20220262.3/0808A/R0/VF

Central Barangaroo Early Works DA1 - Response to Authorities Comments

2 DEPARTMENT OF PLANNING COMMENTS

Figure 1: Site and Surrounds

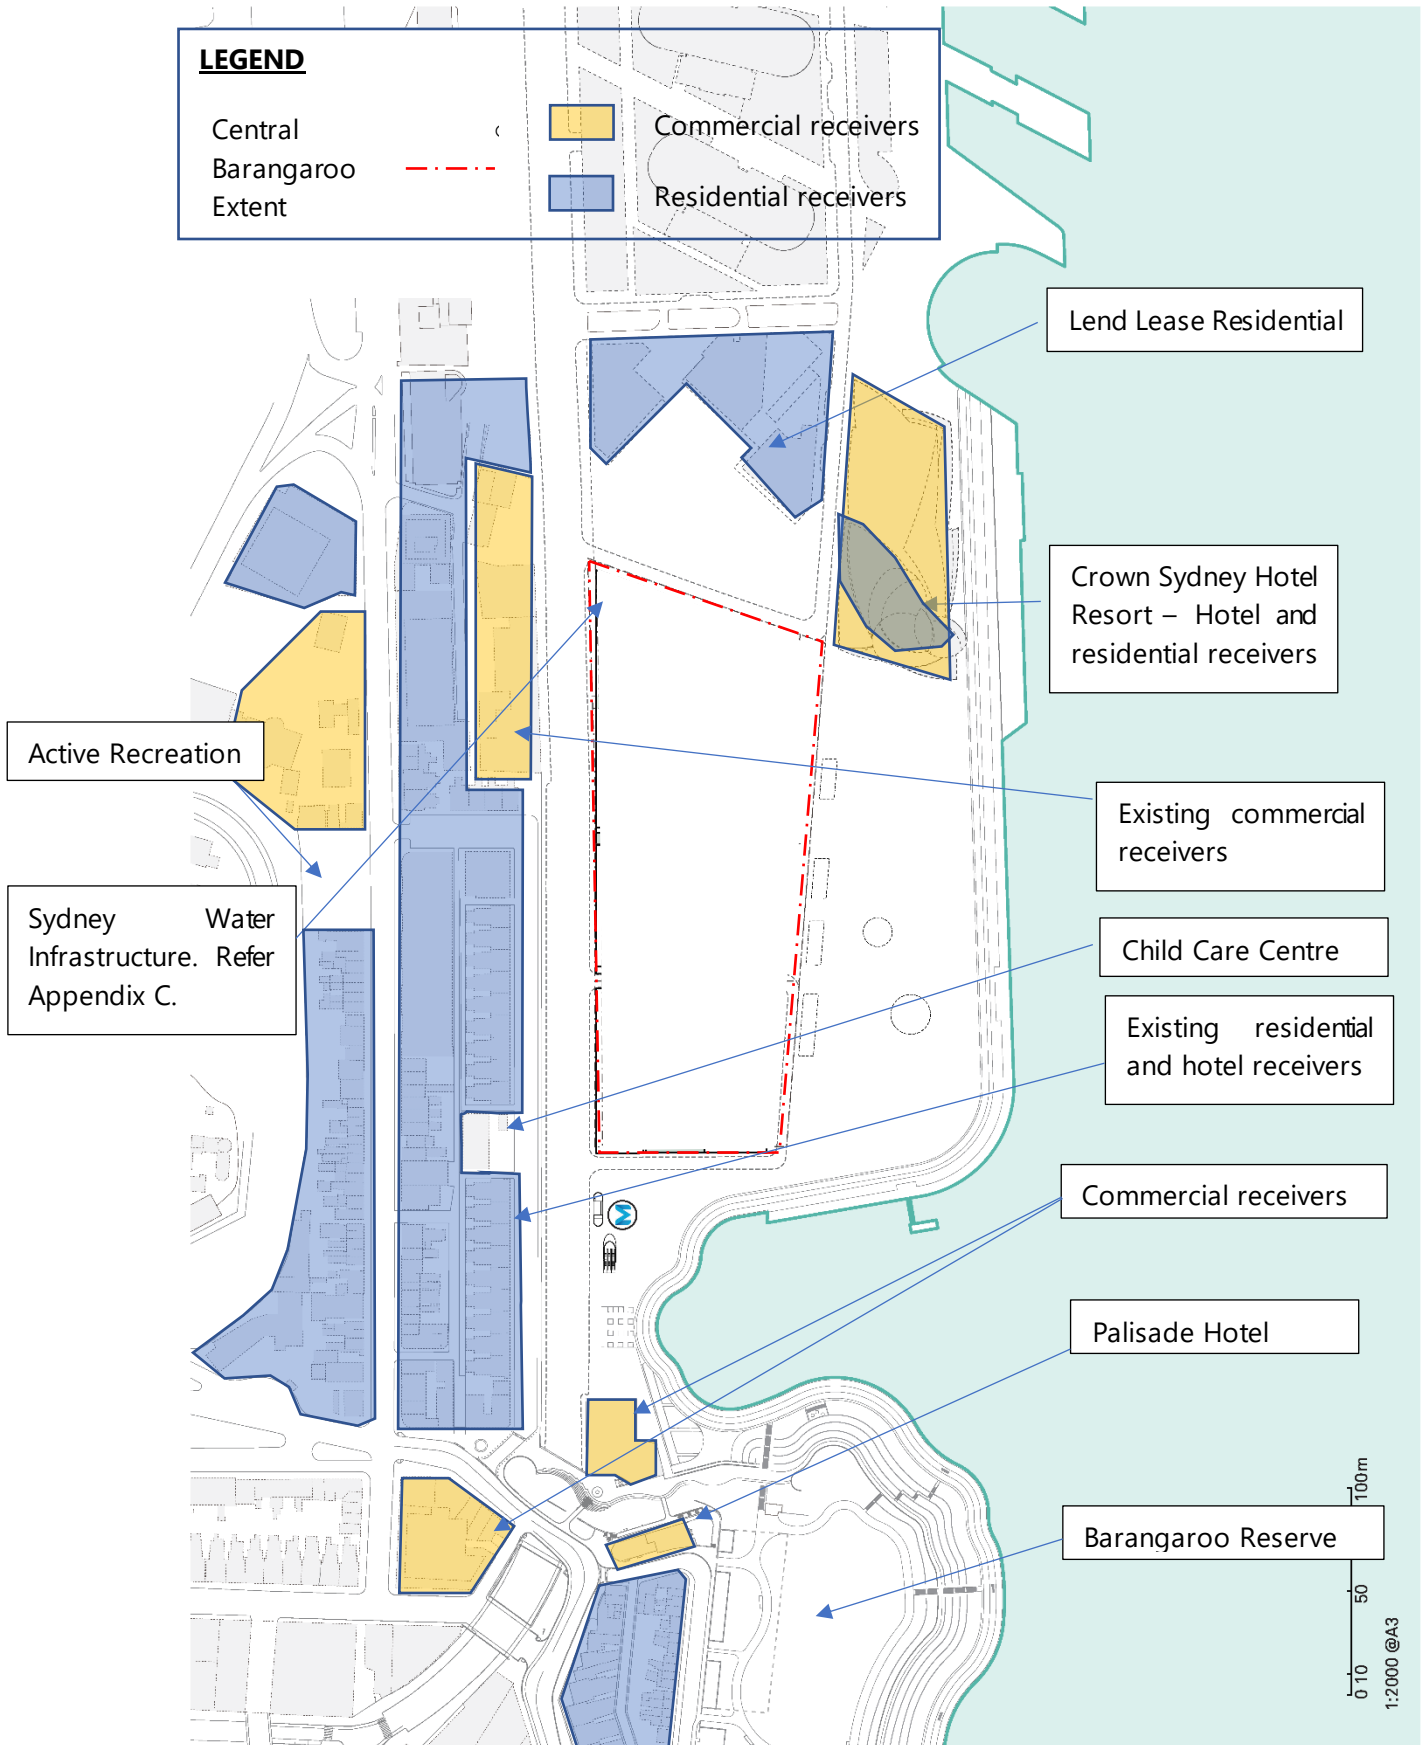
The acoustic assessment incorrectly classifies nearby residential receivers along Hickson Road as commercial receivers in error (e.g. 38 Hickson Road). Please provide an updated acoustic assessment that details:- the noise management levels for all residential receivers opposite the site along Hickson Road - the anticipated noise levels during construction at these additional receivers - all appropriate mitigation measures, including the estimated reduction of construction noise levels when these measures are used.

The assessment report has been revised to show these receivers as being residential (refer Figure 1 in the assessment report), and the appropriate noise management levels specific to these receivers have been included (Table 6). The noise levels generated by construction activities were modelled and included in the previous report. The predicted noise levels (refer Tables 8 and 9 in the assessment report) did not exceed the management level at these receivers, and therefore no additional noise management is required to address noise to these receivers.
